Department of Primary Industries

OUT15/12111

**Oakdale Central Warehousing & Distribution Facility (SSD 6078 Mod 2)
Proposed Modification**

Figure 1: Approved Layout – Lot 2B

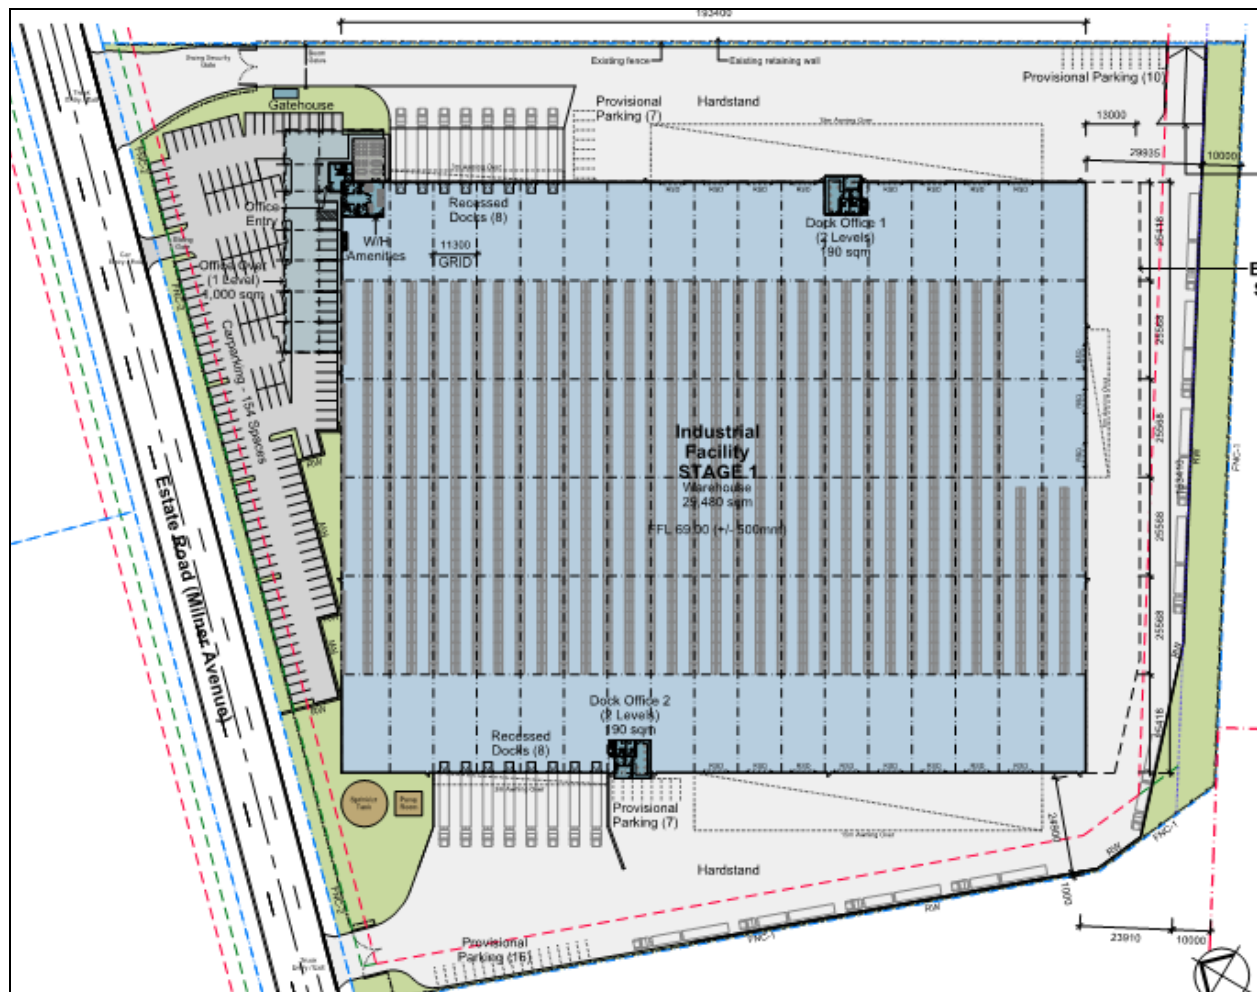
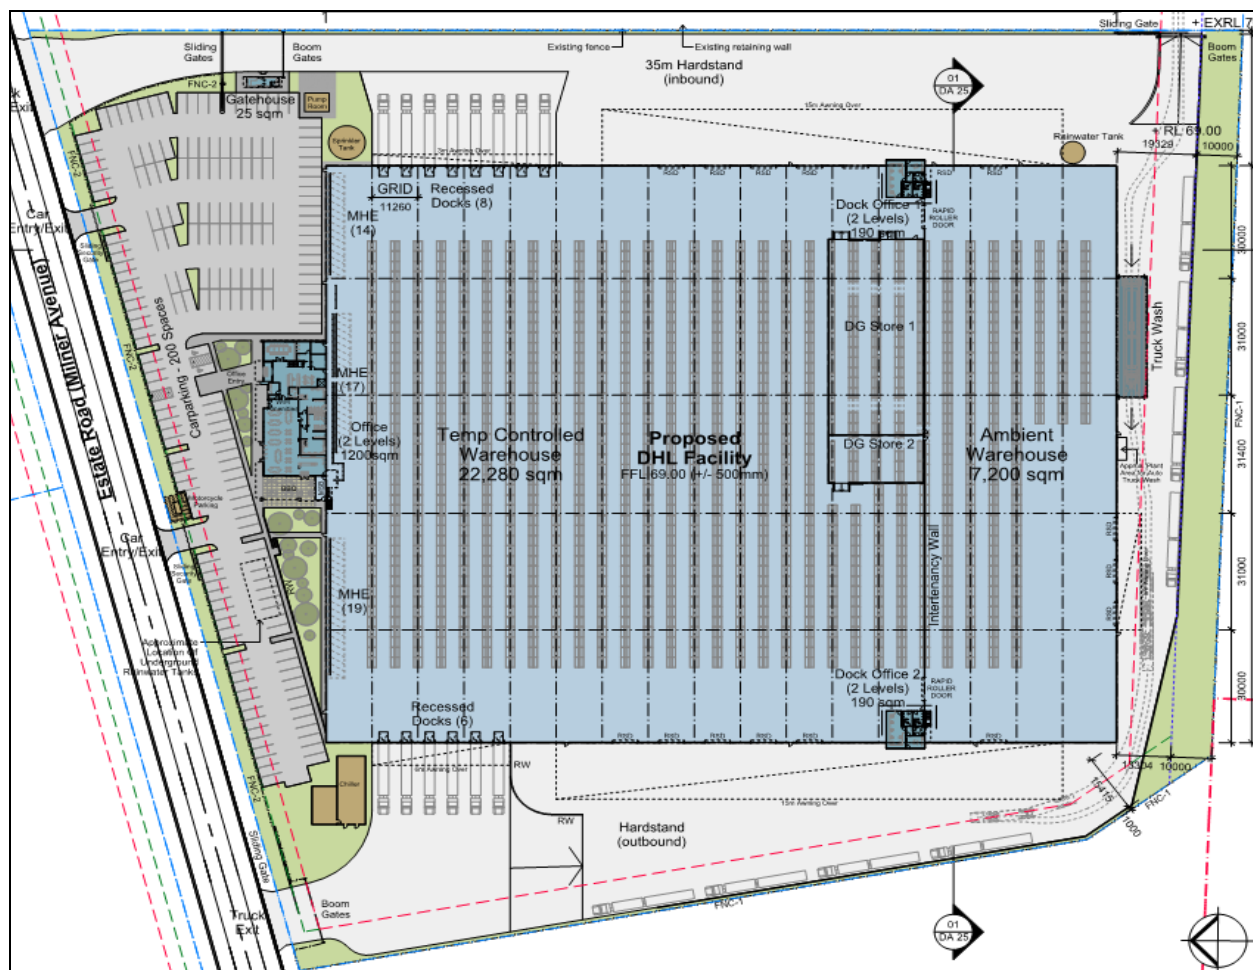
Comparing Figure 1 (approved layout) with Figure 2 (proposed layout) in the EIS, it is noted the proposed layout for Lot 2B has deleted the provisional parking which had previously been approved to be located adjacent to the Biodiversity Lot A along the western boundary of Lot 2B. As the provisional parking area is no longer required and there appears to be no other purpose for this area as part of the MOD 2 application, it is suggested that the following Condition of Approval be included;

"The provisional parking area on Lot 2B which has been deleted as part of the MOD 2 application is to be landscaped with local native plant species from the relevant vegetation community to enhance and improve the adjoining Biodiversity Lot A riparian corridor".
